Please ask for: Ms Iqraa Malik
Email: iqraa.malik@terraquest.co.uk
Telephone: 01212341390
Our Ref: BE/145/20/HH
Your Ref:
Date: 9th December 2020

Application for Planning Permission for Works or Extension to a Dwelling

Development: A Trapezium kitchen extension room, 5m width x 3.5m (exterior dimensions), in addition to a false garage frontage, incorporating another trapezium outbuilding area for utility use, (non habitable), with a 900mm side alley leading to rear.

Location: 5 Bucksham Avenue Bersted PO21 5DT

AMENDED(2) BLOCK PLAN

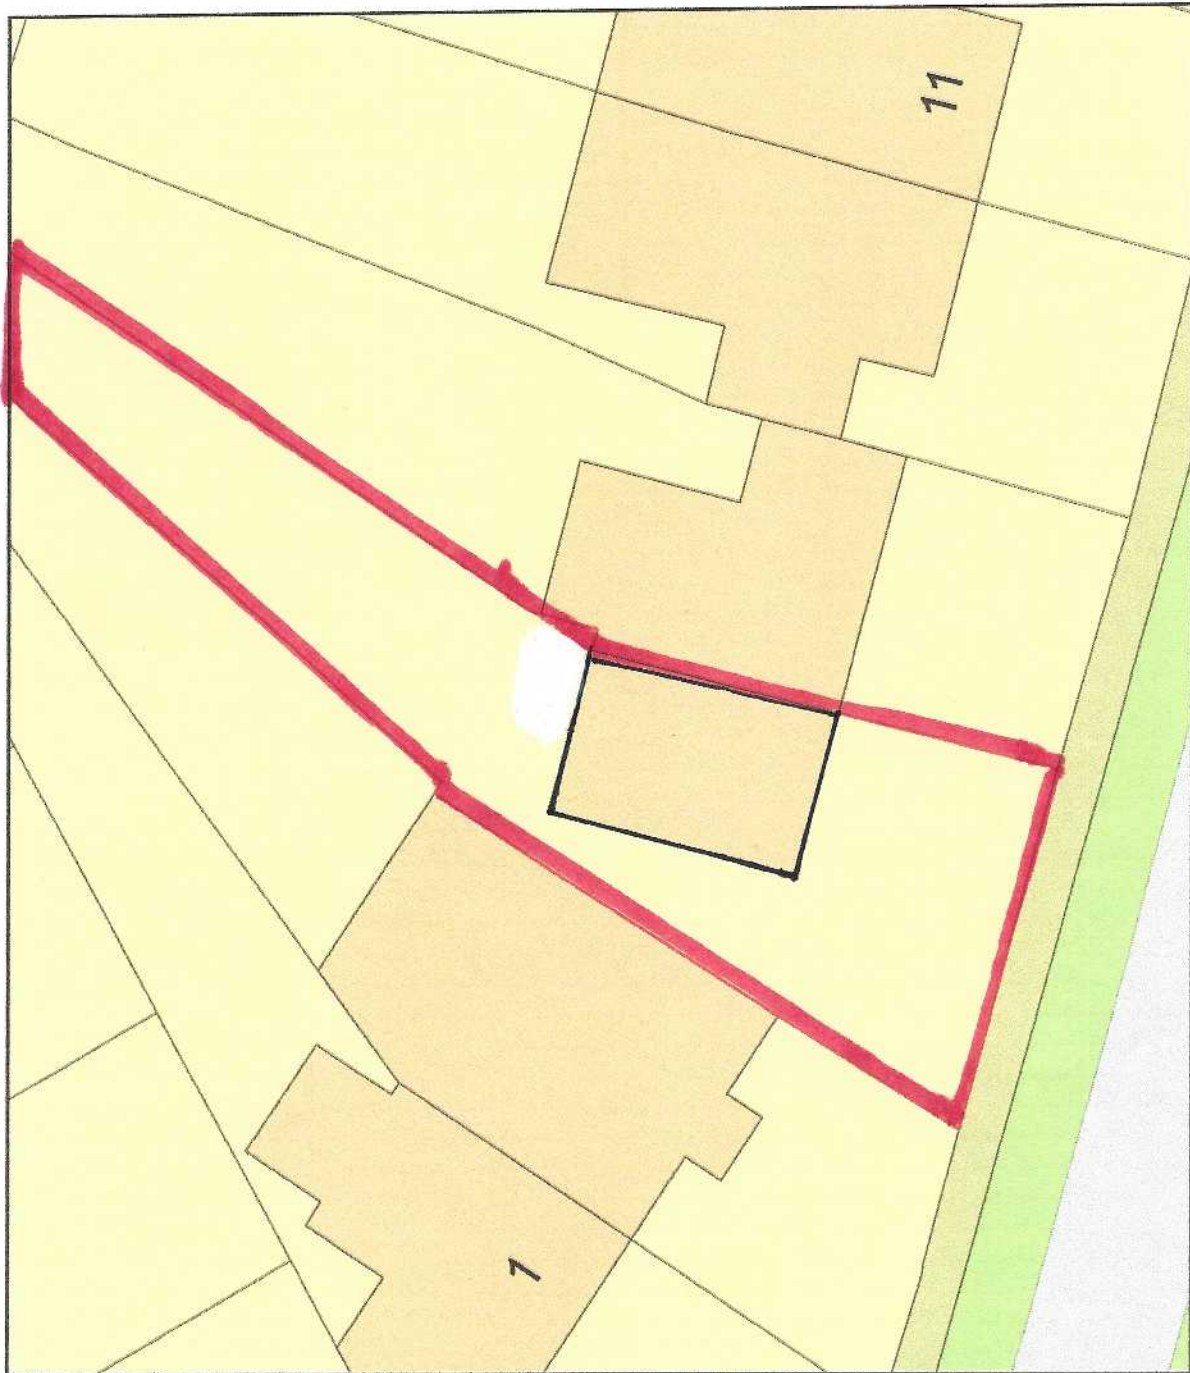
Block Plan

You are required to have dimensions from the proposed extension(s) to all site boundaries. Please amend.
